# Rezoning Transportation Analysis

Petition Number: 2025-107

Date	Description
10-23-25	First Review (TM)

REZONING PLAN

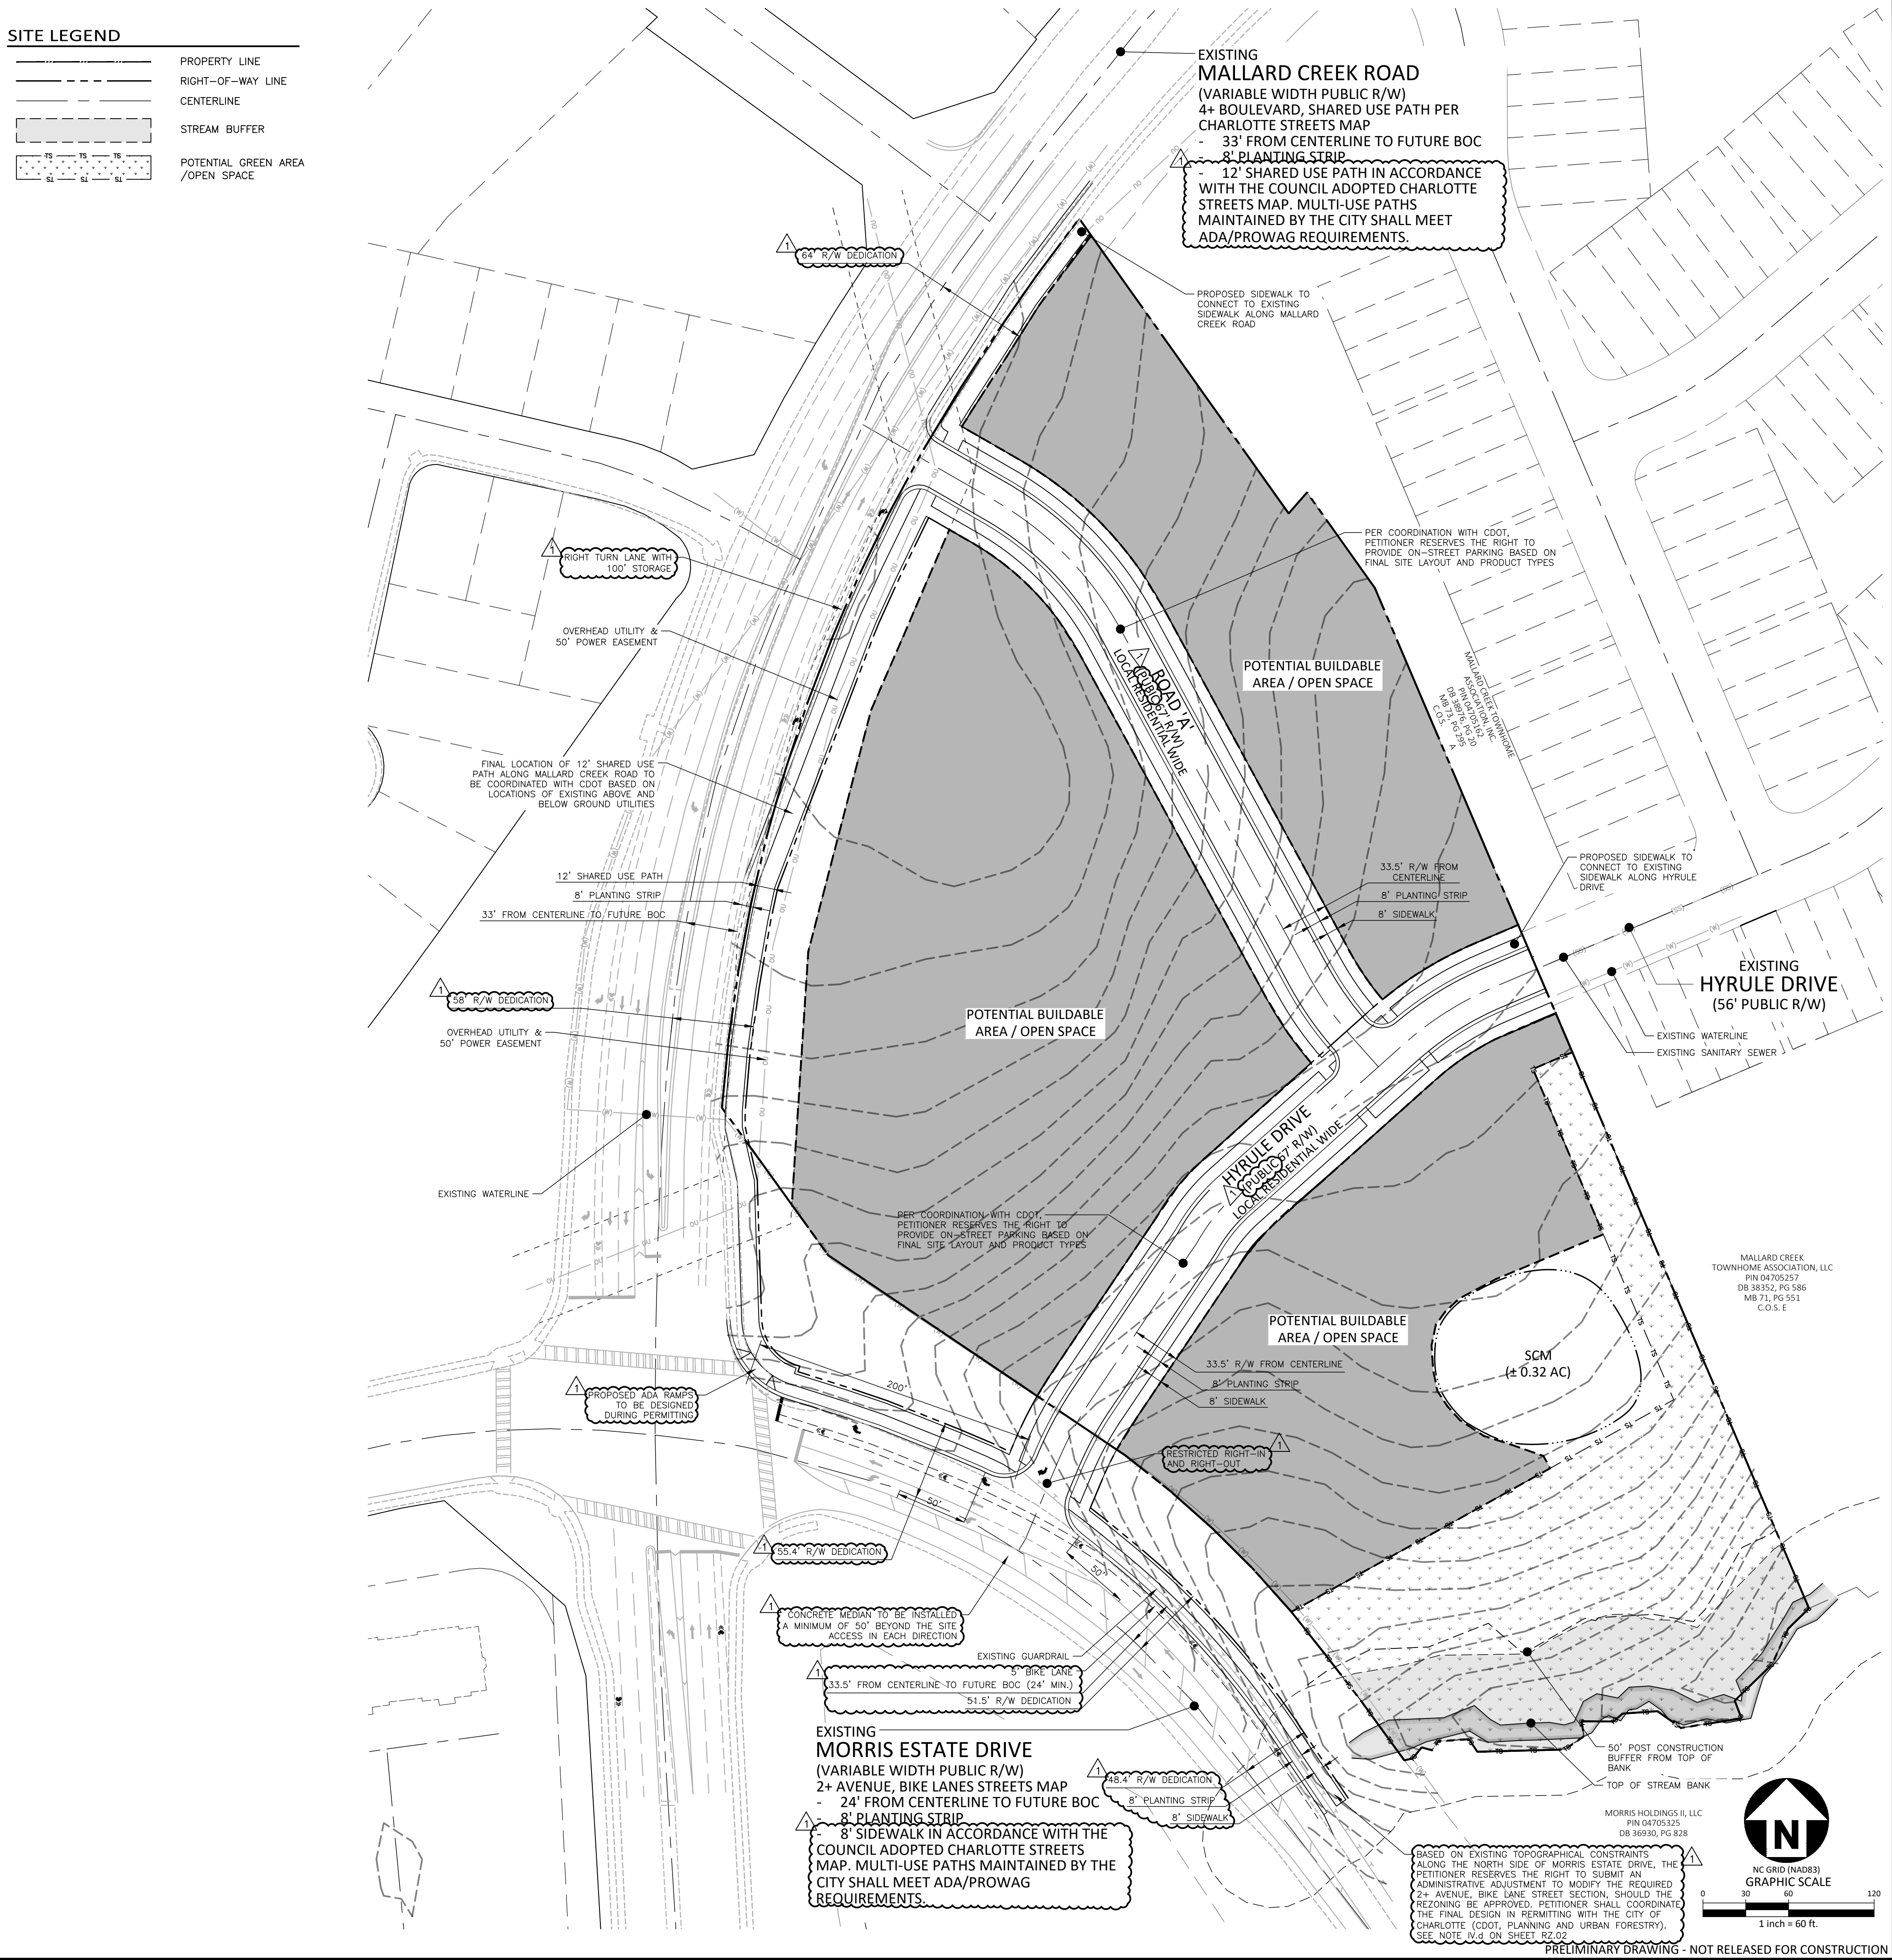
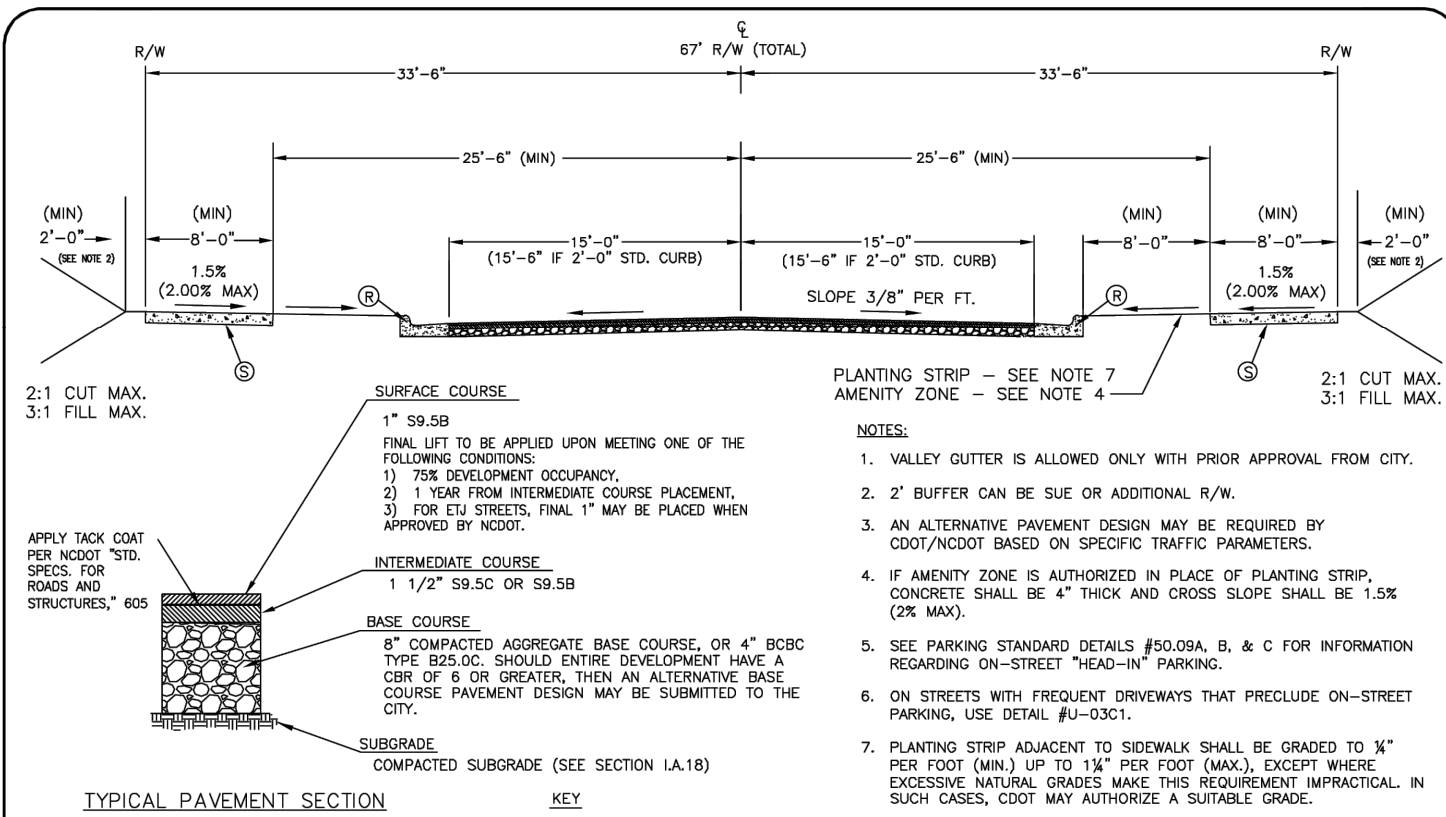
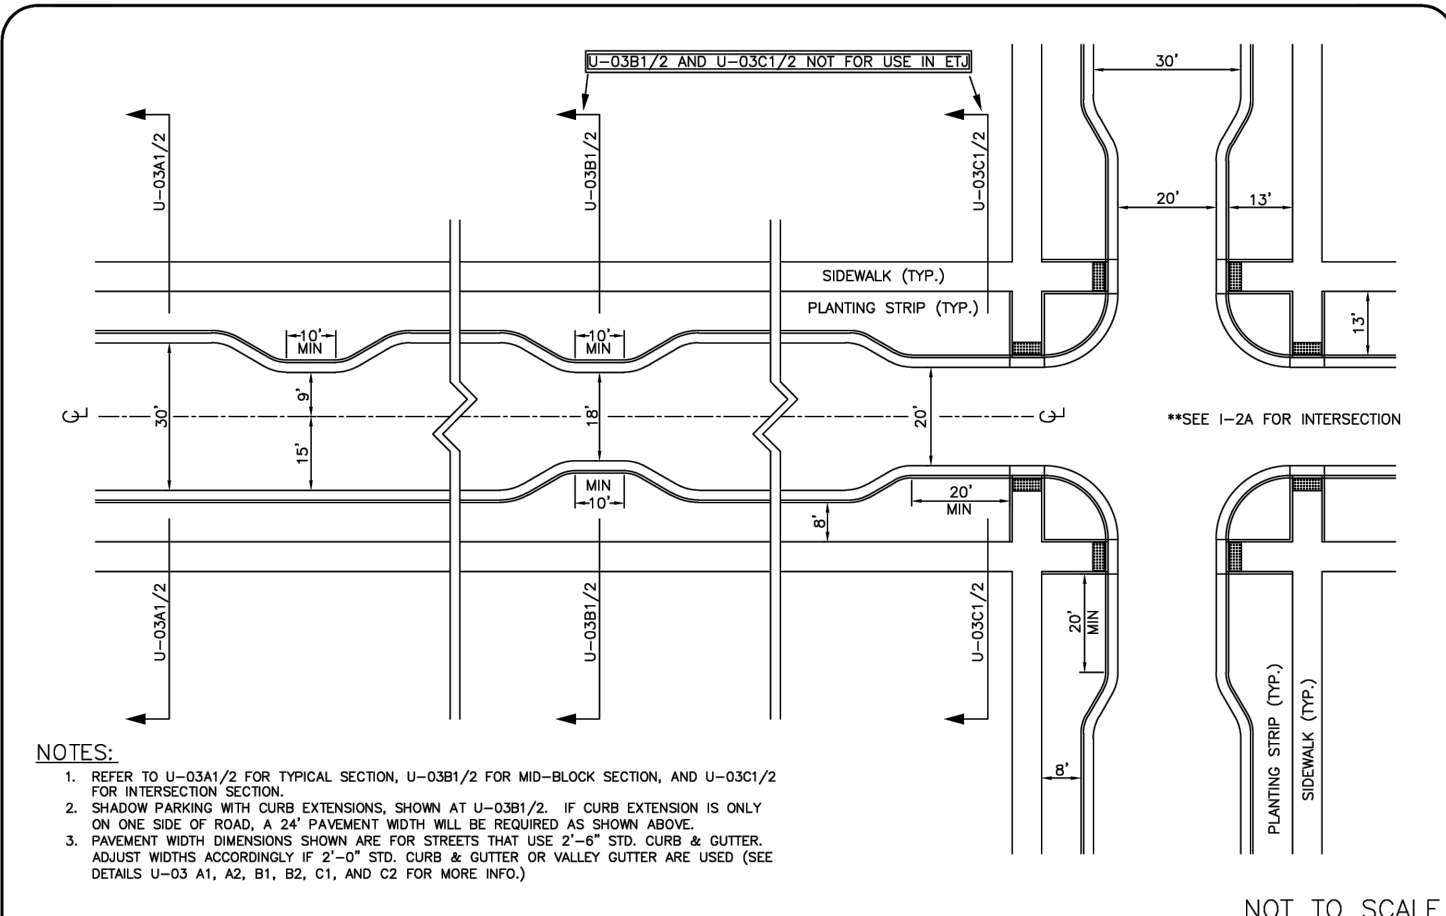
Label and dimension the curb and gutter from the centerline for each road on the site plan.

3. Revise site plan and conditional note(s) to commit to a min dedication of 42-feet of right-of-way from the road centerline along Morris Estate Drive (Placing the right-of-way 2 feet behind sidewalk). IF existing ROW exceeds this minimum amount then ROW shall remain in its existing location. The site plan shall label and dimension the right-of-way from the road centerline to 2-feet behind the sidewalk.

4. Revise site plan and conditional note(s) to commit to a min dedication of 55-feet of right-of-way from the road centerline along Mallard Creek Road (Placing the right-of-way 2 feet behind the shared use path). IF existing ROW exceeds this minimum amount then ROW shall remain in its existing location. The site plan shall label and dimension the right-of-way from the road centerline to 2 feet behind the shared-use path.

5. Revise site plan and conditional note(s) to commit to construct bicycle facilities by installing a 12-foot multi-use path in accordance with the council-adopted Charlotte Streets Map on Mallard Creek Road. Multi-use paths maintained by the City shall meet ADA/PROWAG requirements.

6. Revise site plan and conditional note(s) to commit to construct bicycle facilities by installing a 8-foot sidewalk in accordance with the council-adopted Charlotte Streets Map on Morris Estate Drive. Sidewalks maintained by the City shall meet ADA/PROWAG requirements.

11. Revise site plan and conditional note(s) to commit to restricting access to Morris Estate Drive to a Right-In Right-Out (RIRO) access. A concrete median shall be installed from the intersection of Mallard Creek Road and Morris Estate Drive to 50-feet beyond the site access (measured from the curb return on the plan east side of the Morris Estate Drive site access). Median shall also accommodate existing roadway infrastructure. Site plan shall show existing turn lanes and other infrastructure. Add dimensions and callouts to the site plan committing to this improvement. In addition add conditional note(s) describing this improvement and committing to this access point being RIRO.

12. Revise site plan and conditional note(s) to commit to constructing a right-turn lane (RTL) on Mallard Creek Road per NCDOT requirements. Site plan shall show RTL with 100-feet of storage at the intersection of Mallard Creek Road and "Road A". Design to be finalized during permitting in coordination with NCDOT and CDOT.

13. Revise site plan and conditional note(s) to commit to installing an 8-foot planting strip and an 8-foot sidewalk along the Morris Estate Drive roadway frontage. Site plan is to label and dimension from the roadway centerline.

14. Revise site plan and conditional note(s) to commit to constructing curb line in the future back of curb location in accordance with the UDO and the council-adopted Charlotte Streets Map. Curb and gutter to be placed at a min of 24-feet from the roadway centerline. Site plan shall dimension the curbline from the roadway centerline to the FBOC location. Add a conditional note committing to this improvement.

15. Revise site plan and conditional note(s) to commit to removing the mid-block pedestrian ramps and adding ramps at the intersection of Road A and Hyrule Drive.

16. Revise site plan and conditional note(s) to commit to providing ADA ramps at the intersection of Morris Estate Drive and Mallard Creek Road. Final design of ada ramps to be designed during permitting. Show 2 ramps on the site plan and add conditional note(s) to the conditional note(s) committing to this improvement.
